Application for a non-material amendment following a grant of planning permission.

Number	
Suffix	
Property name	Wickes Building Supplies Limited
Address line 1	Victoria Road
Address line 2	
Address line 3	
Town/city	Ruislip
Postcode	HA4 0QB

Installation of Cover Trolley Park, Customer entrance, Installation of new door to Outdoor Projects Centre, Recladding of Building, 3 x van parking spaces.	
Reference number:	43138/APP/2018/150
Date of decision	01/05/2018

Part-implementation only of new cladding. Outdoor Projects Centre Removed. Canopy Retained. New Roller Shutter Goods Entrance (instead of new OPC sliding doors)

SBD/20/2224/P2			
Drawn:	Page Size	Scale:	Da

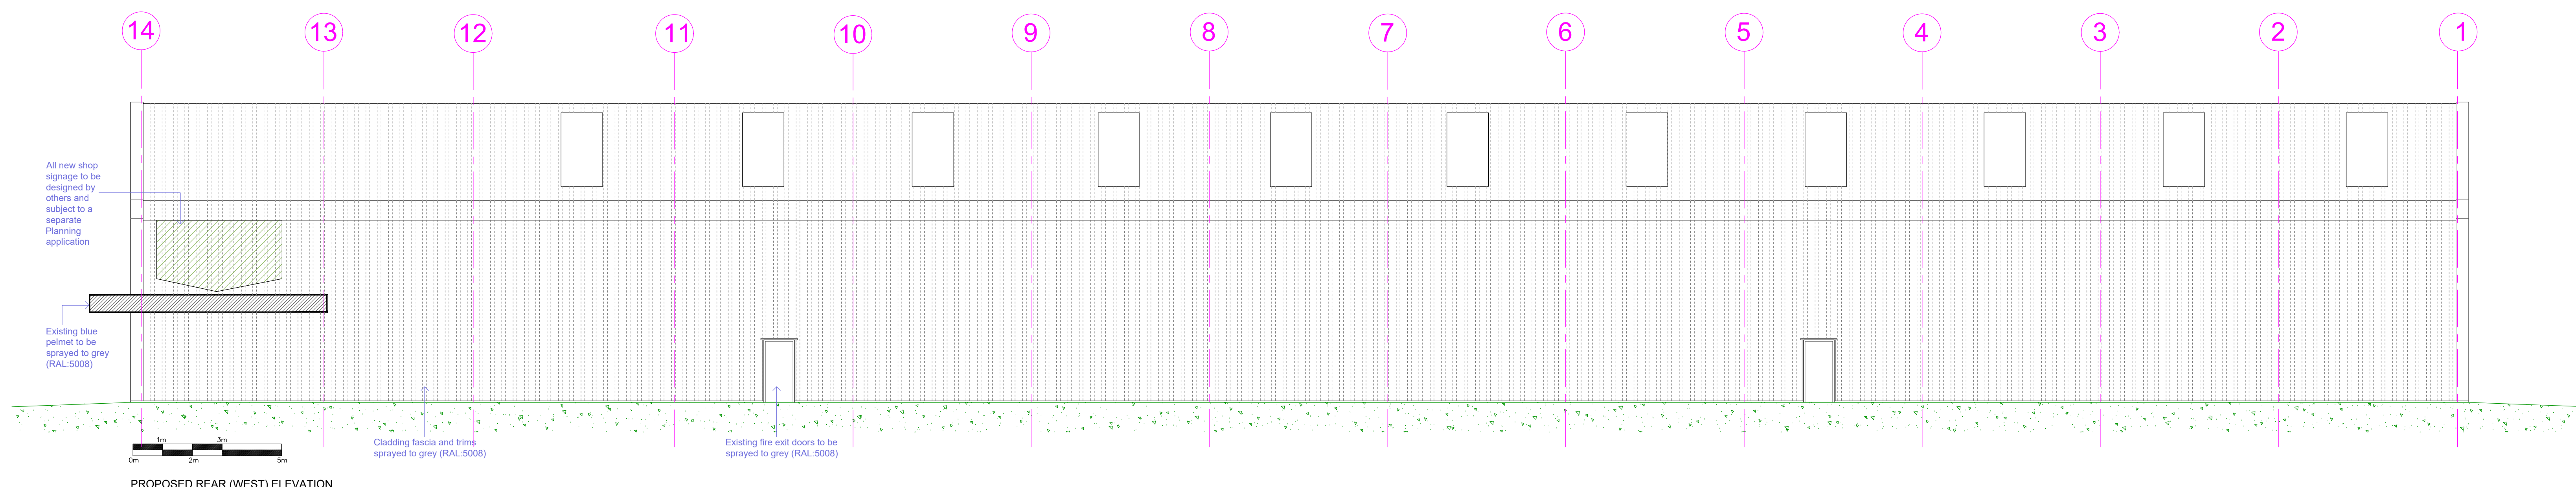
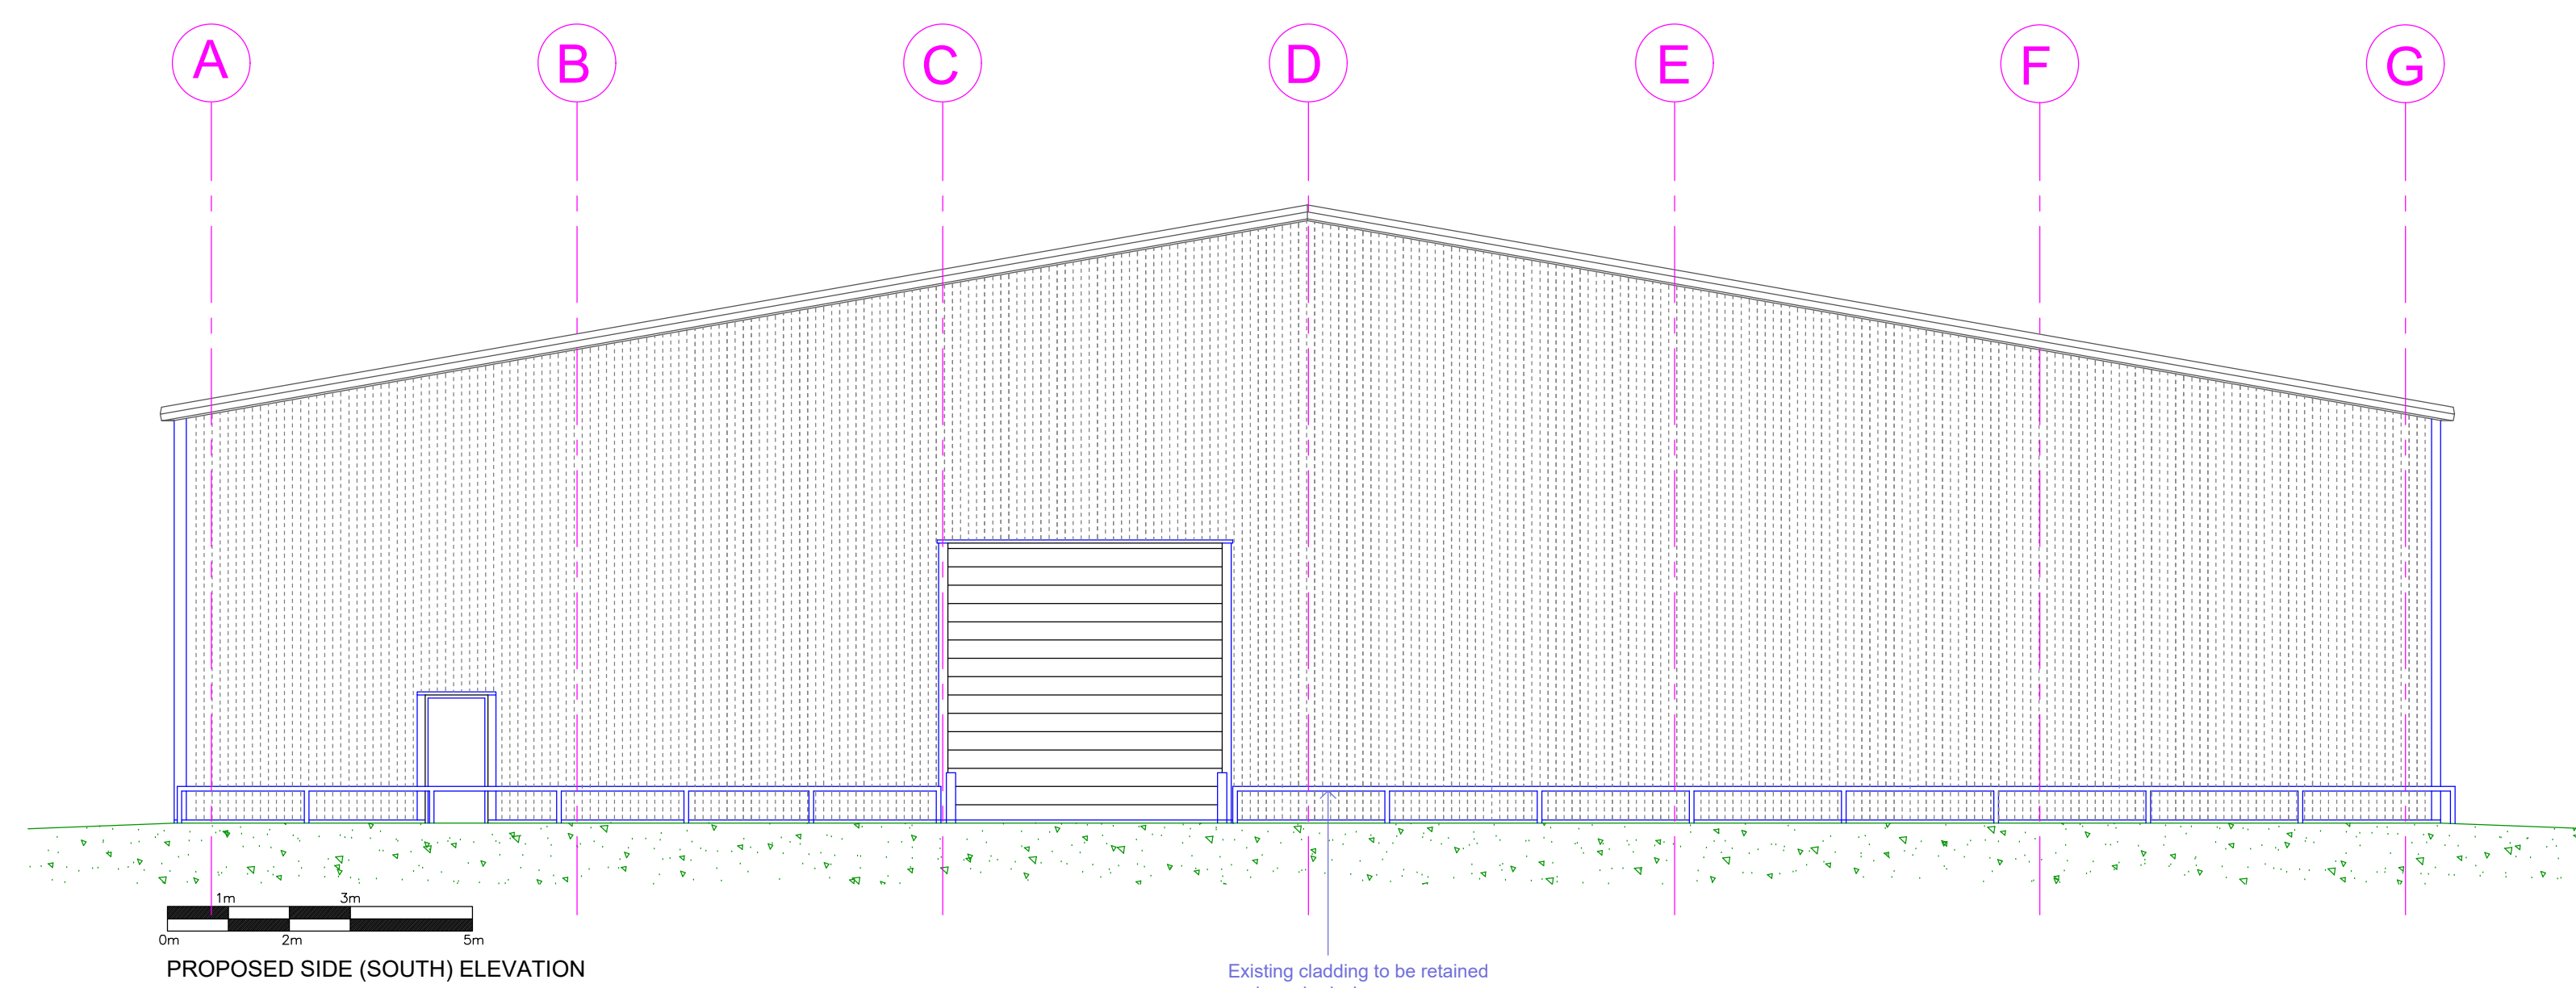
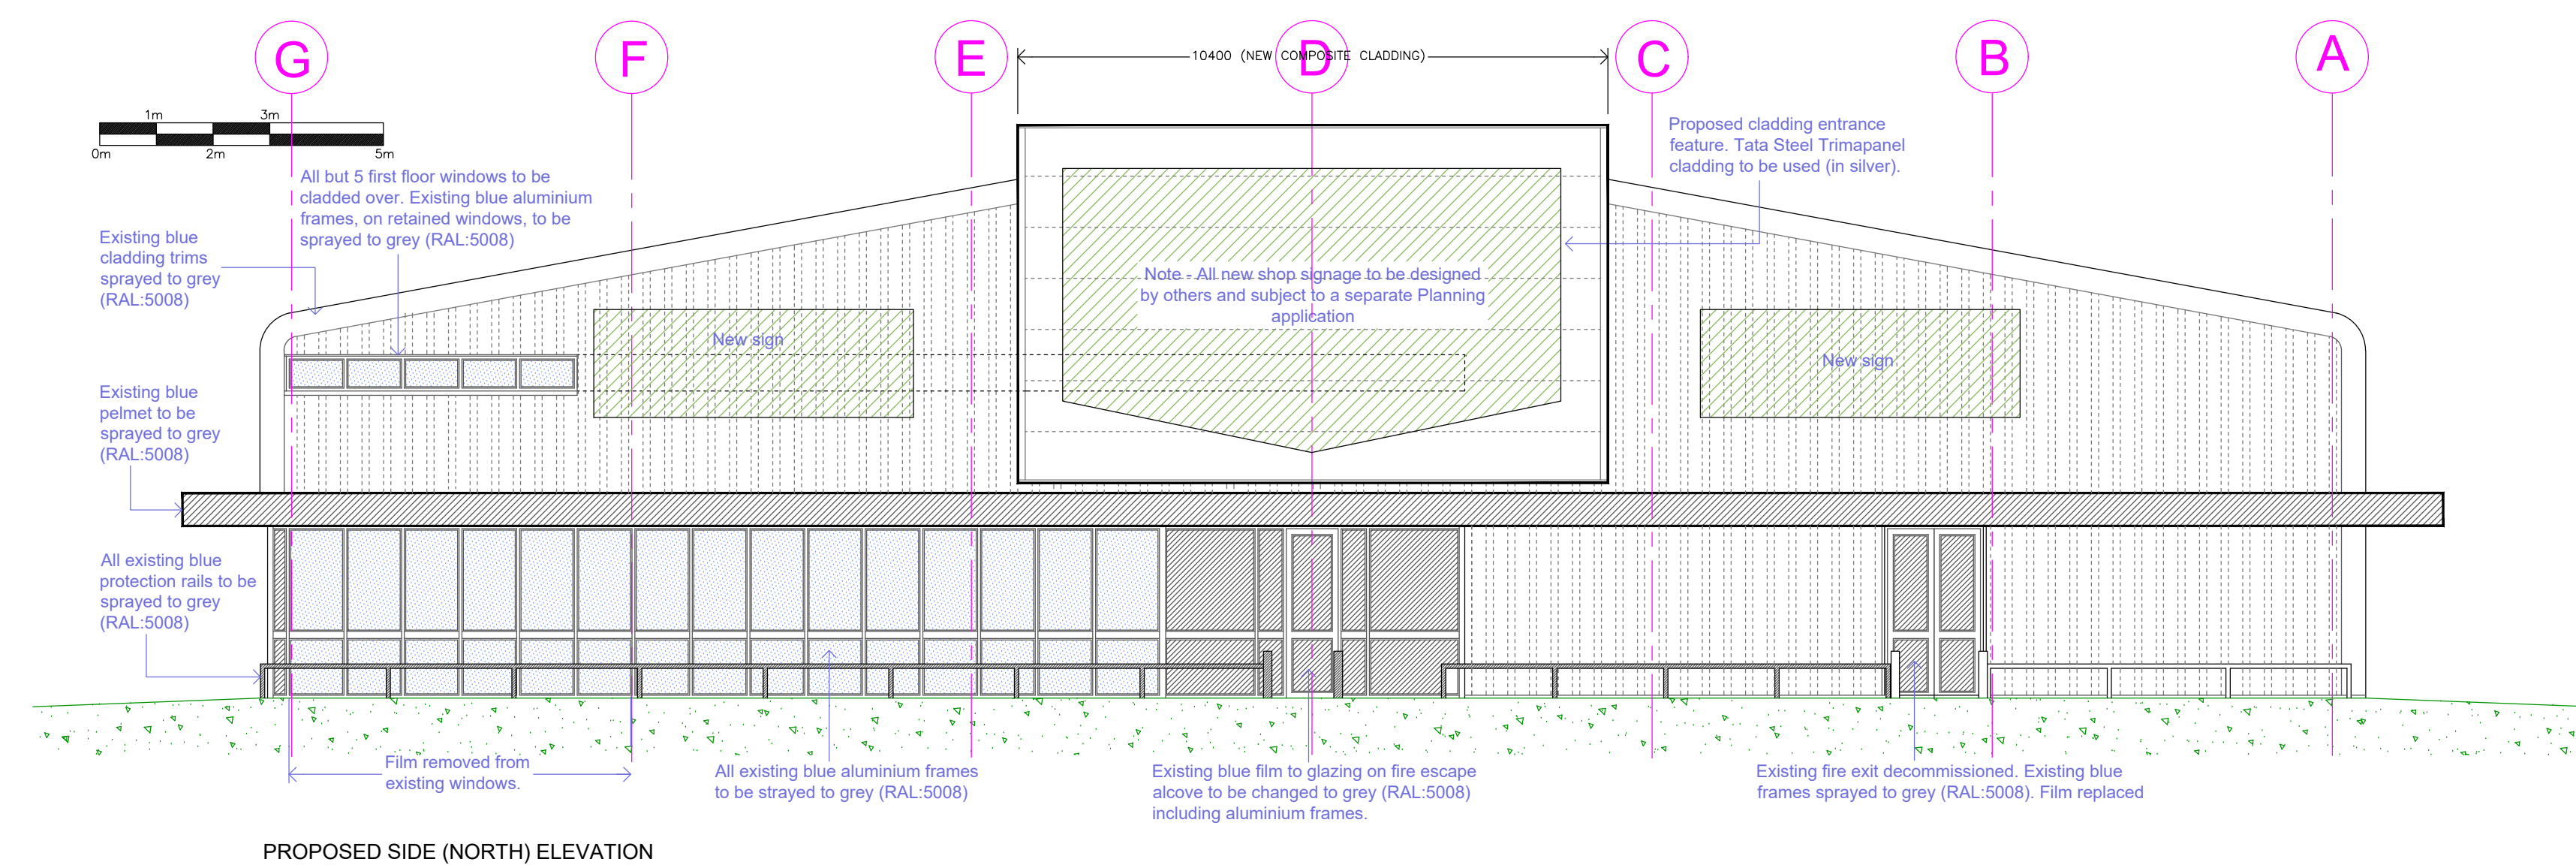
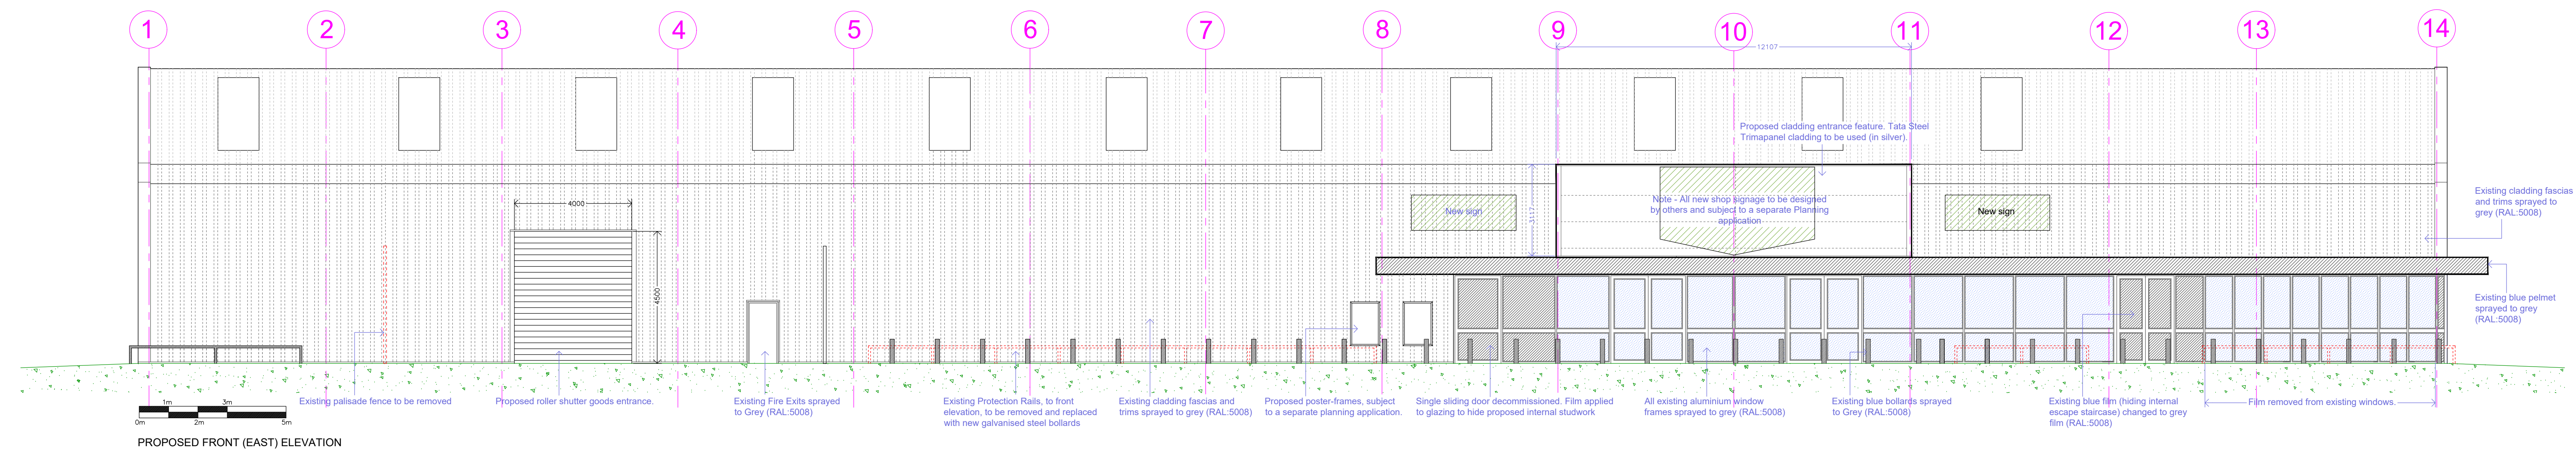
Proposed Site Plan - SBD/20/2224/P1
Proposed Elevations - SBD/20/2224/P2
